Rezoning Transportation Analysis

Petition Number: Insert Zoning Petition #2021-023

General Location Identifier: Tax IDs: 22327148, 22327149, 22327150, 22327151, 22327152

Revision Log:

DEVELOPMENT STANDARDS March 15, 2021

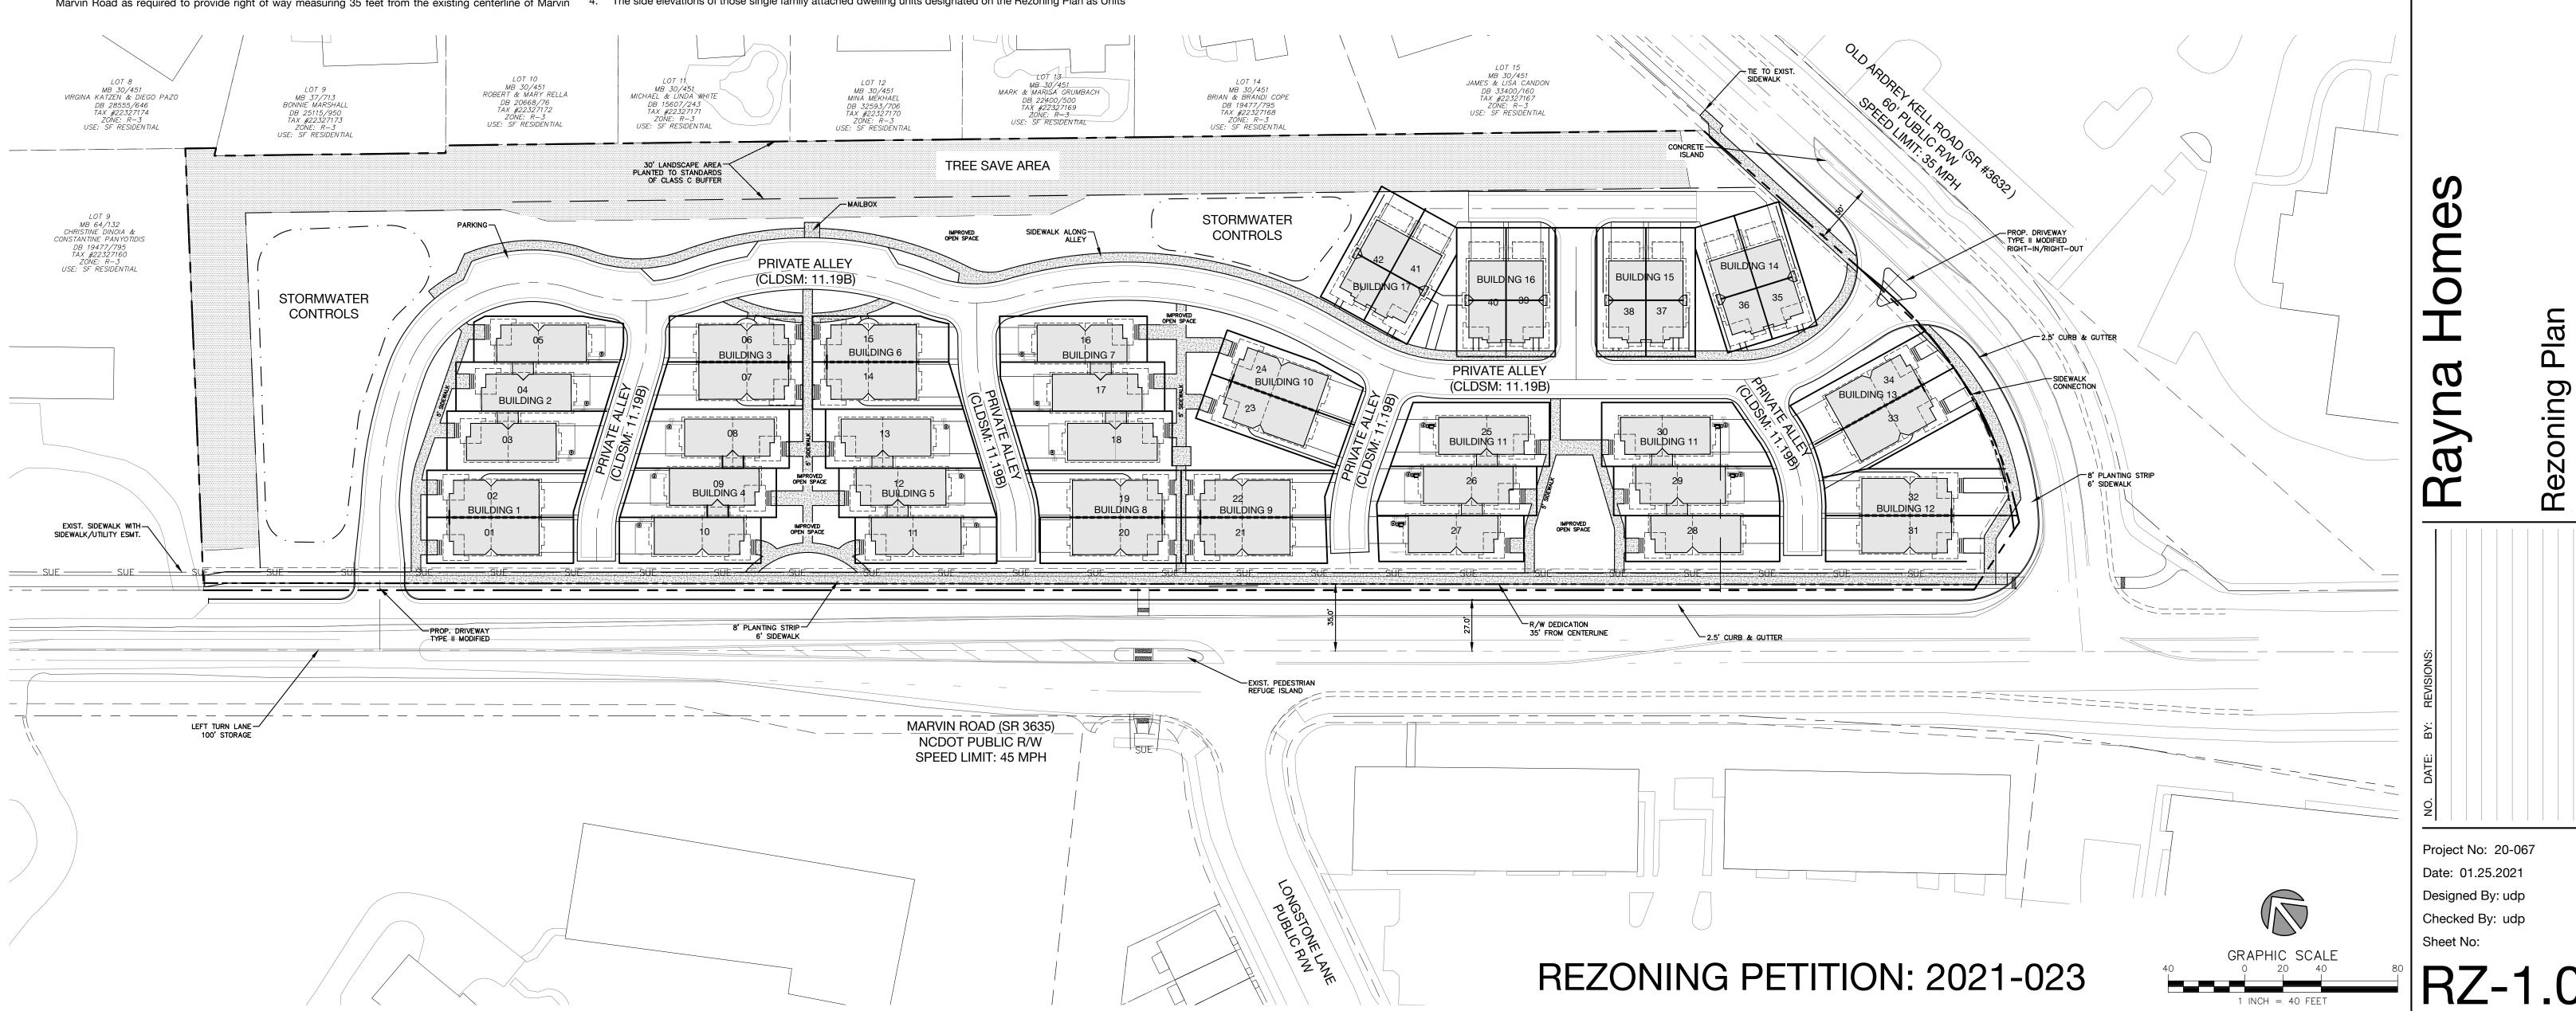
1. ~~**Curbline:** The proposed zoning district has a setback measured from back of the existing or proposed future curbline.~~
 - a. **Resolved (03/18/2021): Marvin Road (NCDOT):** The future location of back of curb and gutter is 27' from the Marvin Road centerline. Label and dimension the curb and gutter from the centerline for each road on the site plan.

Label and dimension the curb and gutter from the centerline for each road on the site plan.

4. **Resolved (03/18/2021):** ~~Revise site plan and conditional note(s) to commit to construct an 8-foot planting strip, and 6-foot sidewalk on Marvin Road and Old Ardrey Kell Road per Chapter 19 / Chapter 20. The site plan shall label and dimension both items from the back of curb and gutter and road centerline.~~

5. **Resolved (03/18/2021):** ~~Provide a left turn lane on Marvin Road as required by NCDOT. Restripe Marvin Road, per NCDOT Roadway Standard Drawing for PAVEMENT MARKINGS Turn Lanes, 1205.05, to accommodate the left turning lane to include 100' storage.~~

6. **Resolved (03/18/2021):** ~~Petitioner will relocate the driveway access point on Marvin Road, as shown per NCDOT, and provide 100' driveway stem.~~

7. **Resolved (03/18/2021):** ~~Petitioner will relocate the driveway access point on Old Ardrey Kell Road. The access point will be a RI/RO with a porkchop median and a center median that will begin from the driveway across the street and continue to the end of the Left Turn Lane (LTL) taper to Marvin Road, as shown per NCDOT and provide 100' driveway stem.~~

8. **Resolved (03/18/2021):** ~~Site plan and conditional note(s) revisions are needed to meet CLDSM standards as required by NCDOT. Provide a pedestrian refuge across Marvin Road, per CLDSM, 11.41, complying with ADA/PROWAG standards. The pedestrian refuge also meets the Charlotte WALKS Policy.~~

10. **Resolved (03/18/2021):** ~~A site plan note(s) specifying dedication and fee simple conveyance of all rights-of-way to the City before the site's first building certificate of occupancy is issued is needed. CDOT requests rights-of-way set at 2' behind back of sidewalk where feasible.~~

11. **Resolved (03/18/2021):** ~~A site plan note specifying that all transportation improvements will be approved and constructed before the site's first building certificate of occupancy is issued is needed. The petitioner may phase transportation improvements if said improvements and phasing are explicitly described in site plan notes.~~

12. **New Comment (4/28/2021):** Based on feedback from the community, please revise the dimension of the concrete island proposed on Old Ardrey Kell Rd. to allow room for more left turn storage at the Old Ardrey Kell and Marvin Rd. intersection.
